# **Attachment 1: Department's Comments on EIS**

Checked By DW	Project Status SUBMISSION	
									Approved By AO	Drawing Title SITE PLAN	
									Scale 1 : 2000 @ A0	Drawing Number A010	Issue 2

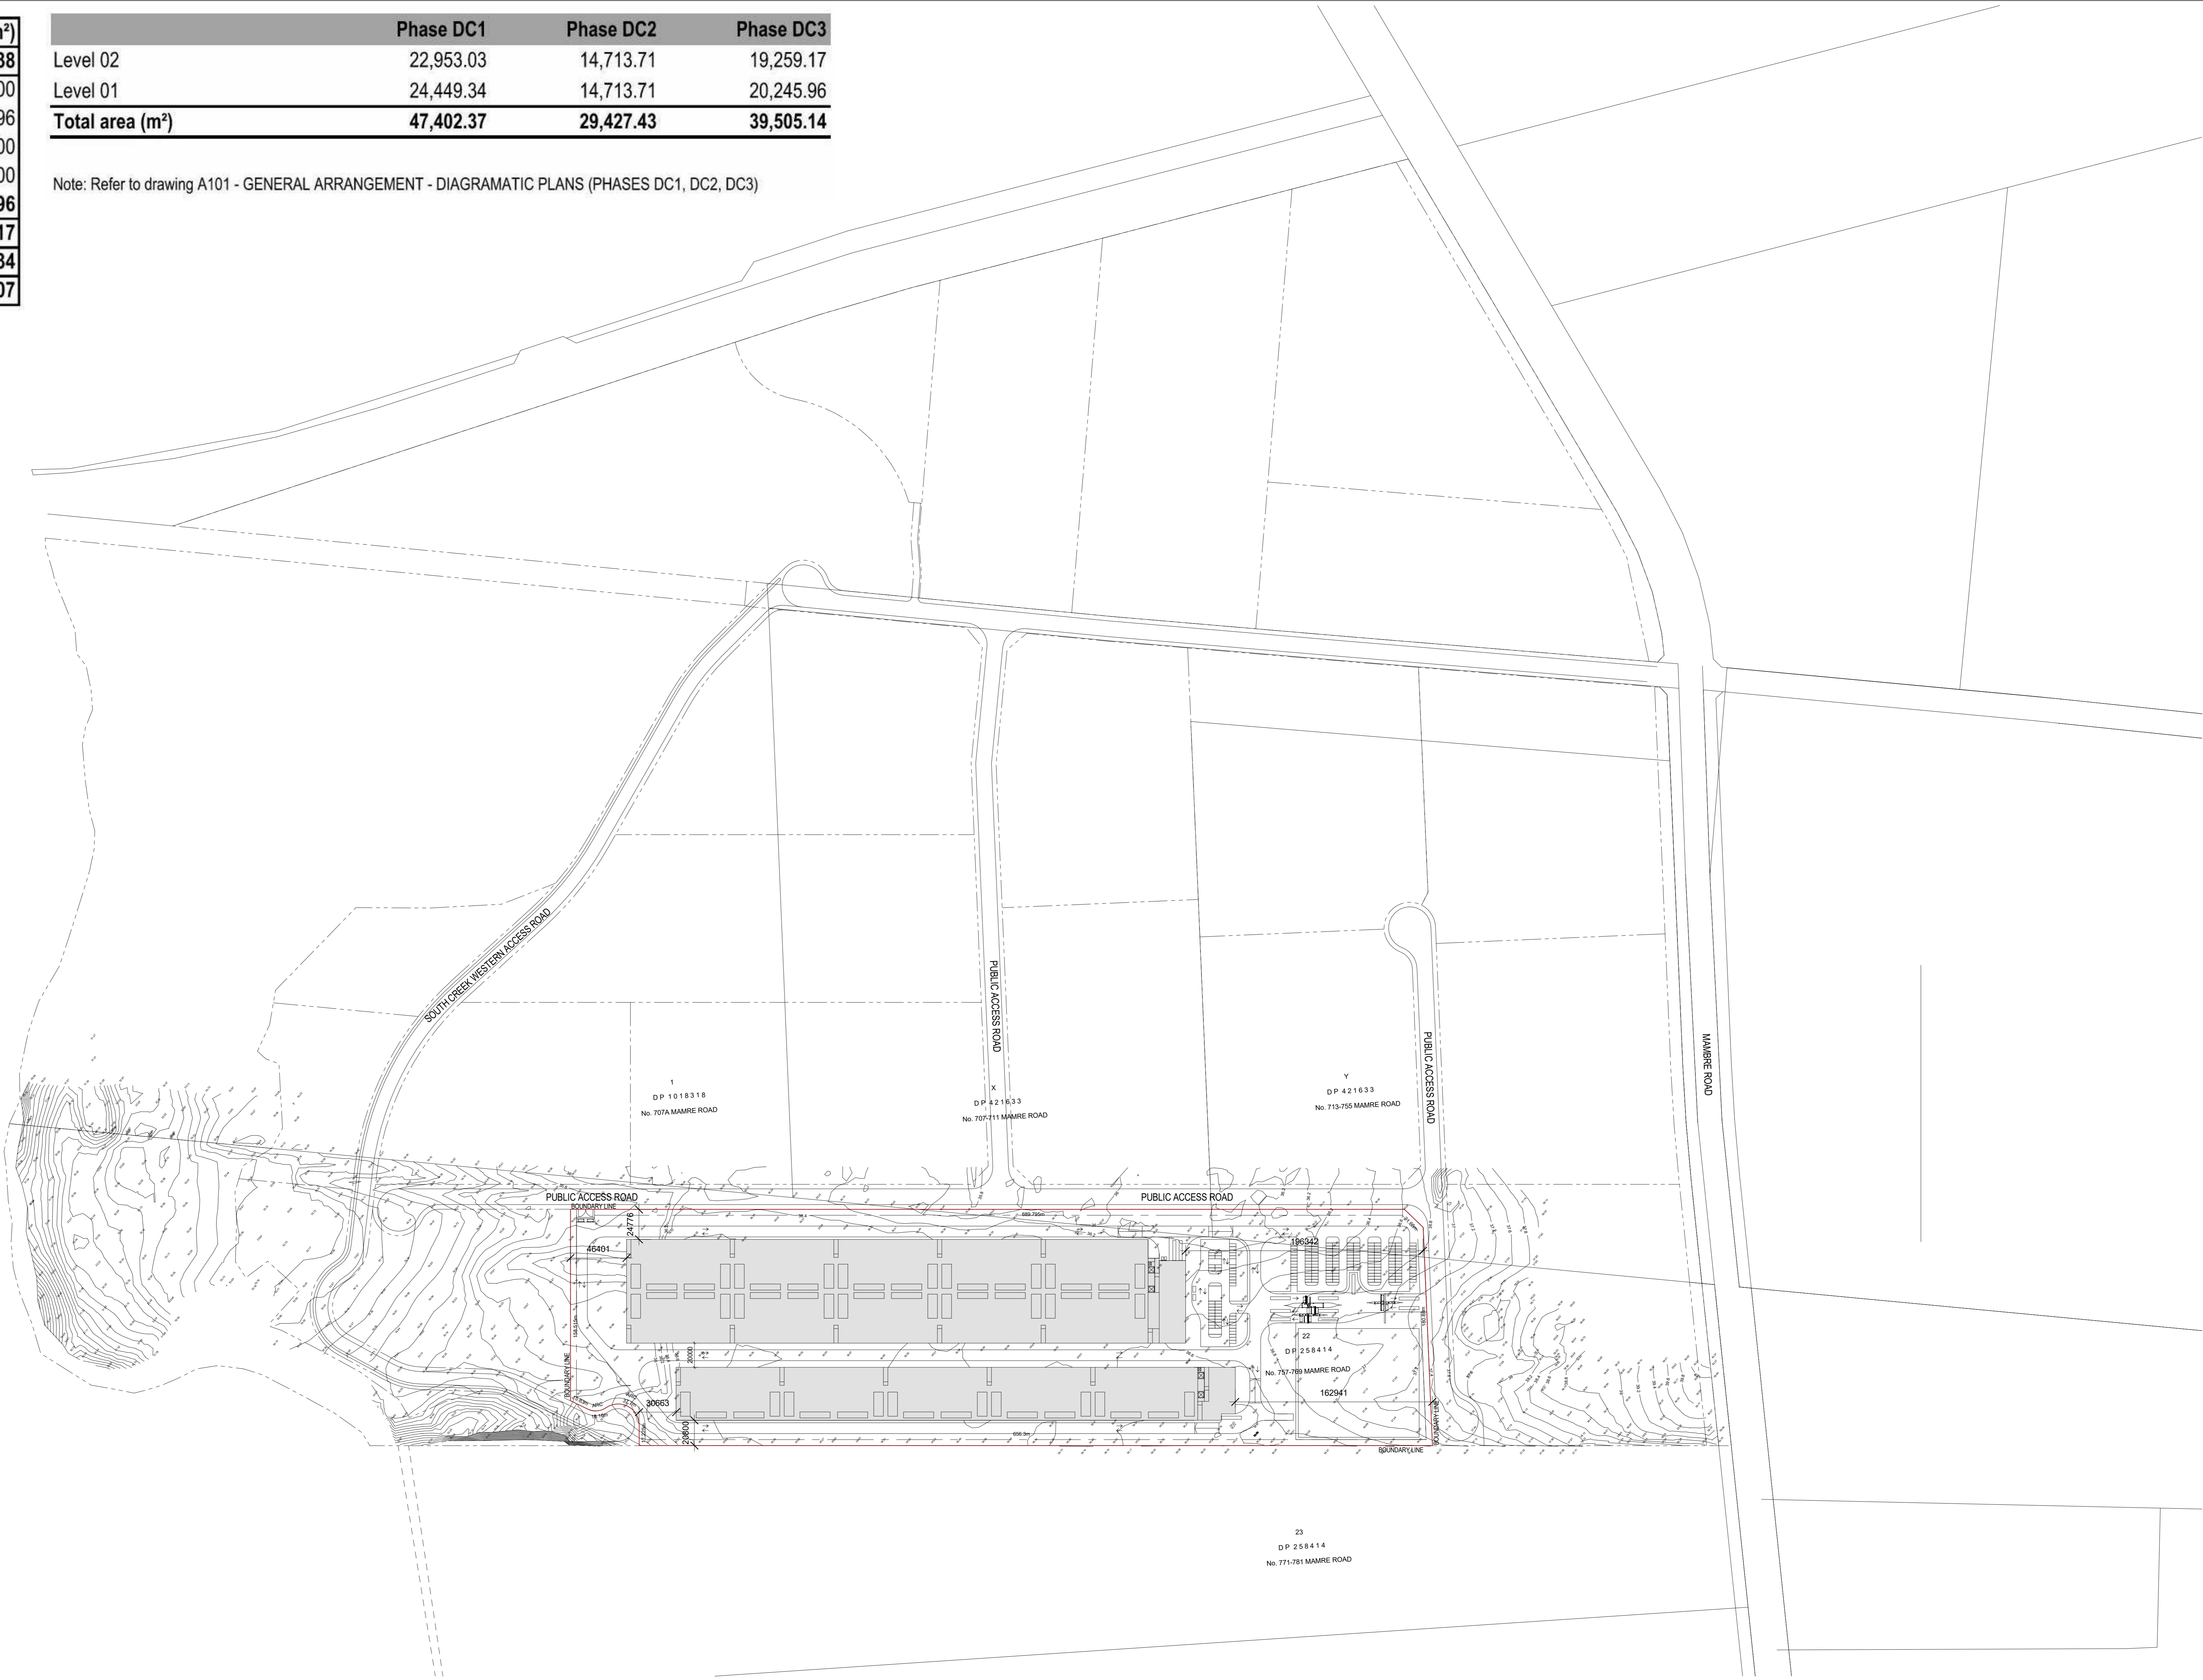
- Section 3.2.7 stipulates the construction of the development is to be undertaken in three stages and is illustrated in Appendix 6 of the EIS. The Department requires further information on the timing of each construction phase and the rationale for why the development is to be constructed as proposed.

- In addition to the above, Section 3.2.7 of the EIS notes the northern-most building of the development is to be constructed first however, the LVIA provided in Appendix 8 of the EIS demonstrates the south-western portion of the development to be constructed initially. The Department requests clarification on the proposed construction staging of the development.
